US-24G (E-X) / Woodmen Road  
El Paso County

January 16, 2025

RE: The Commons at Falcon Field Filing No. 1 (SF2435)

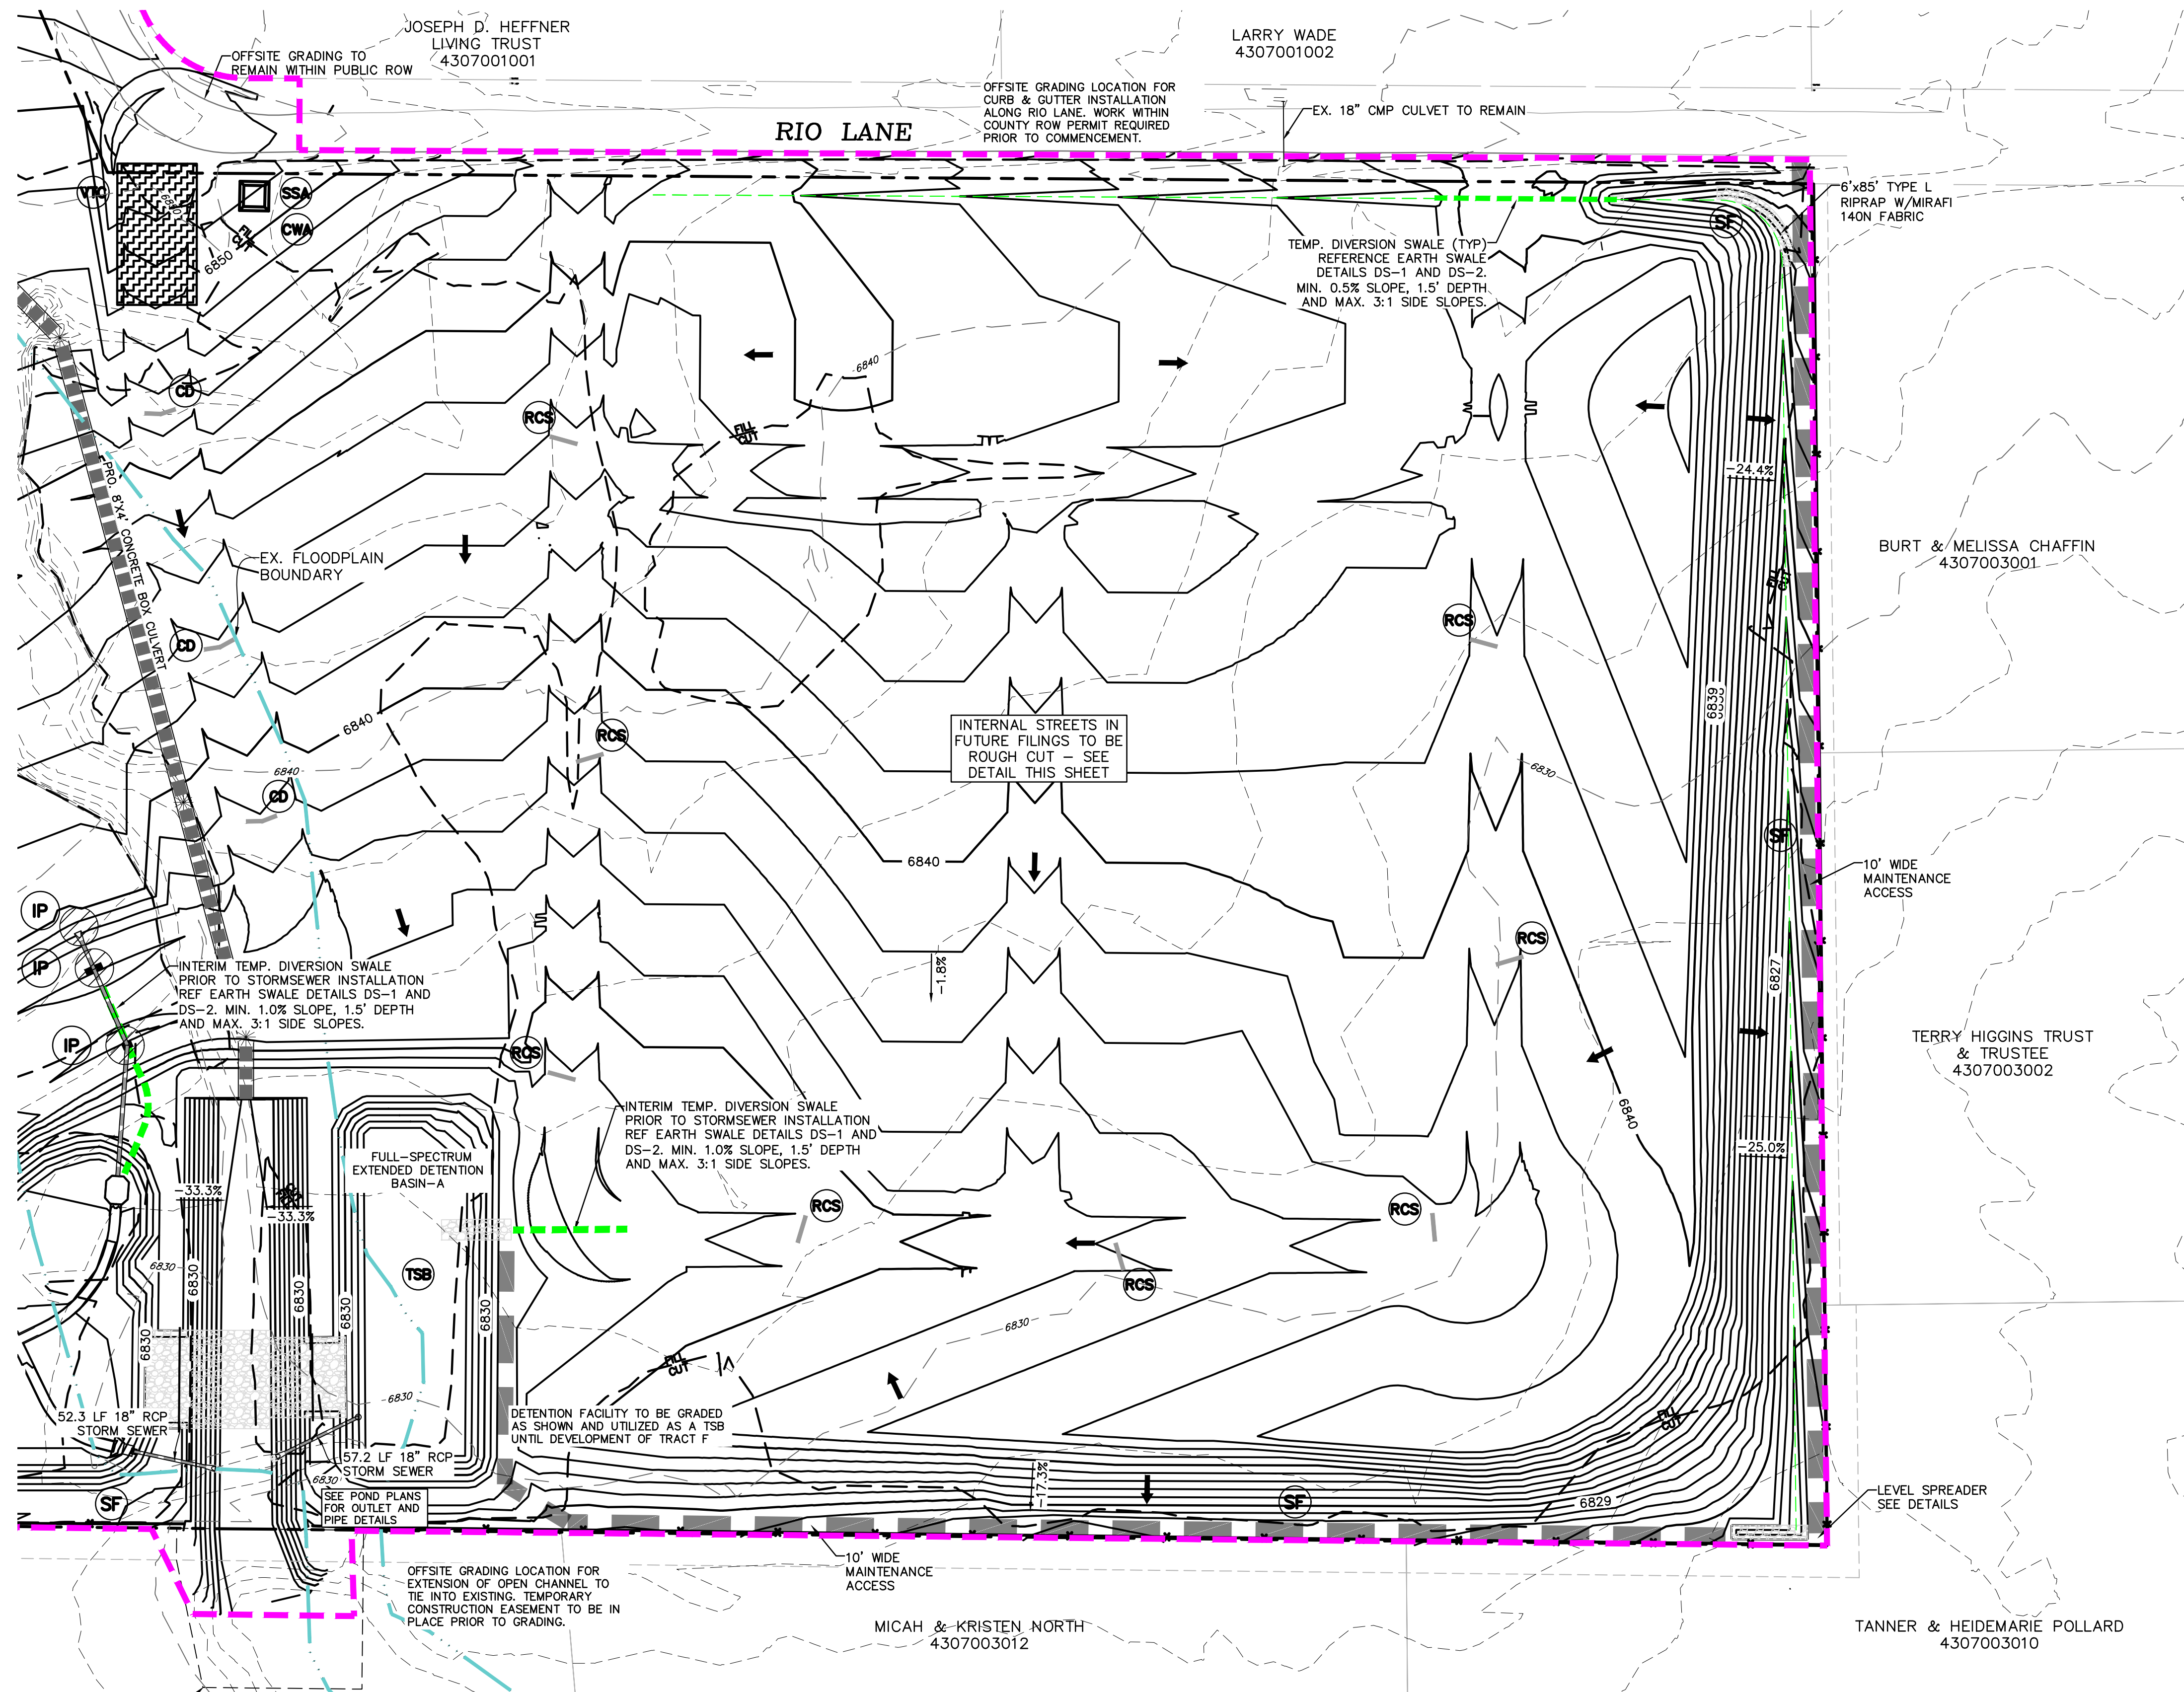
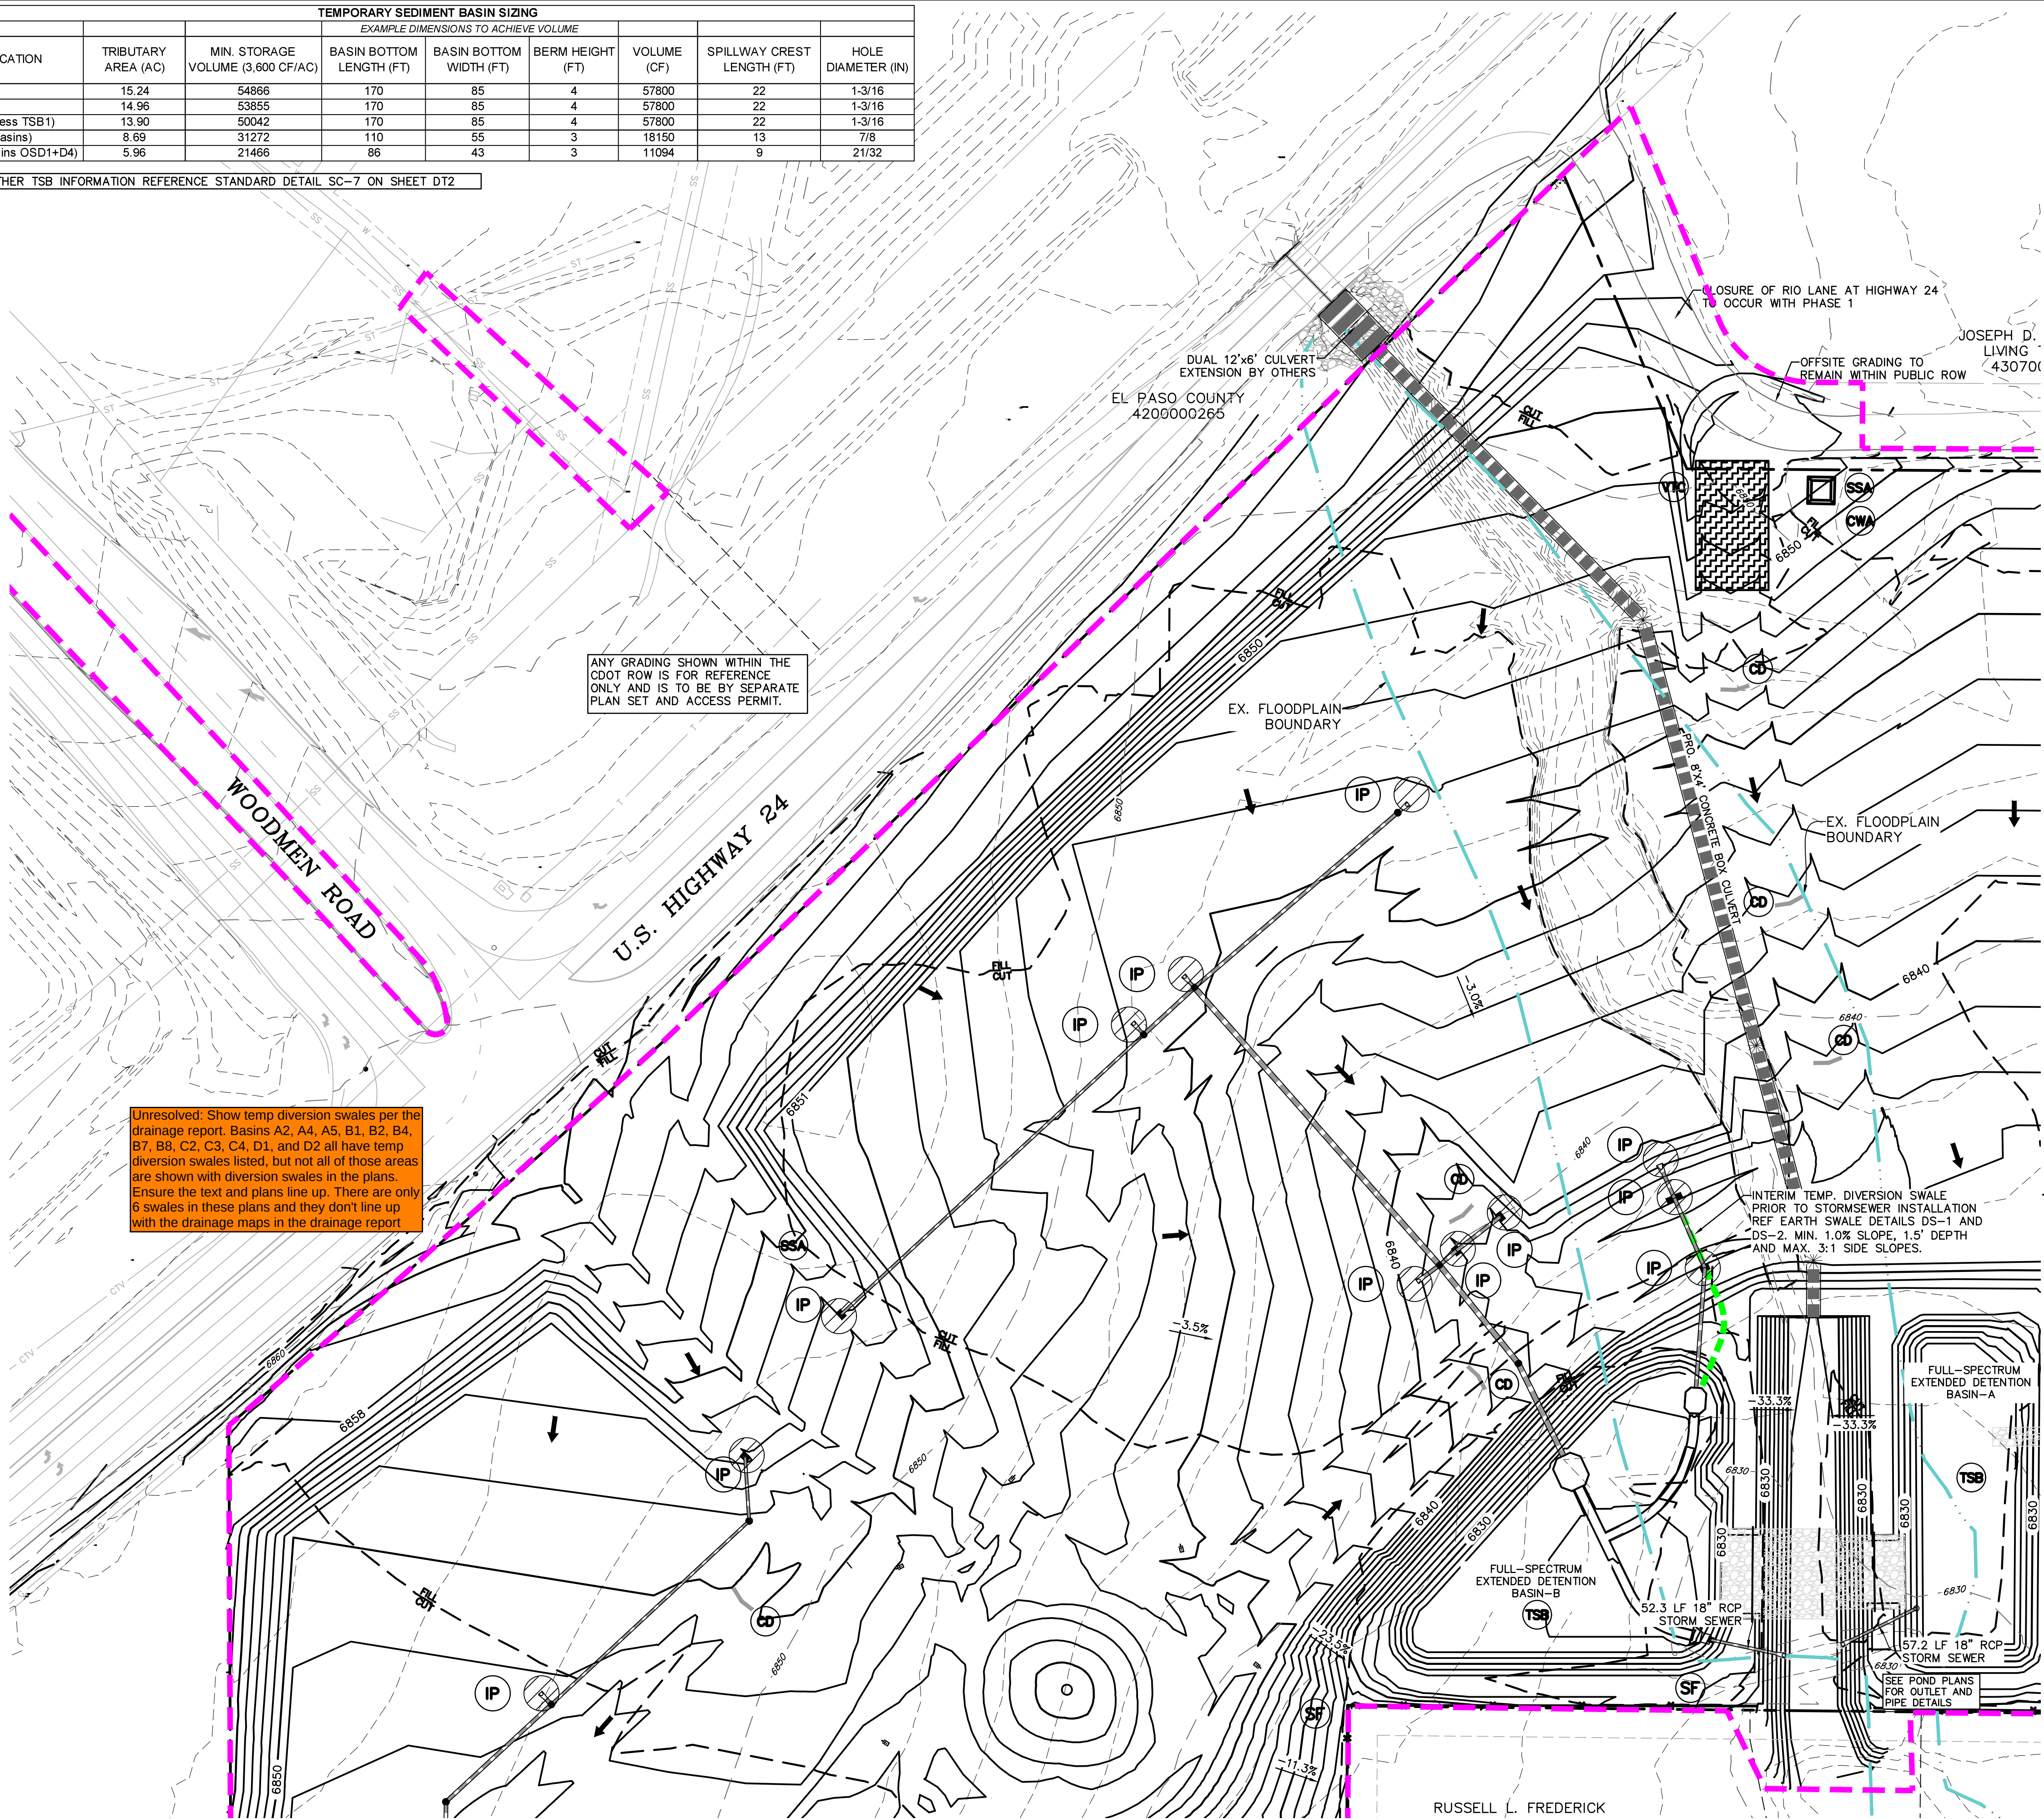
- Plan comments:
  - The grading plans show work to be completed within CDOT right-of-way, but the landscape plans only call for vegetated areas within the project limits.
  - **Verify that the graded areas shown in the GEC plans will be vegetated.**
- Report comments:
  - Is there adequate capacity in the proposed roadside ditches along US-24? Calculations were not included. The grading suggests the ditch is approximately 1' deep.
  - As the grading of the roadside ditches lies within CDOT right-of-way, the capacity should be confirmed for the ultimate condition of the widened US24 section.
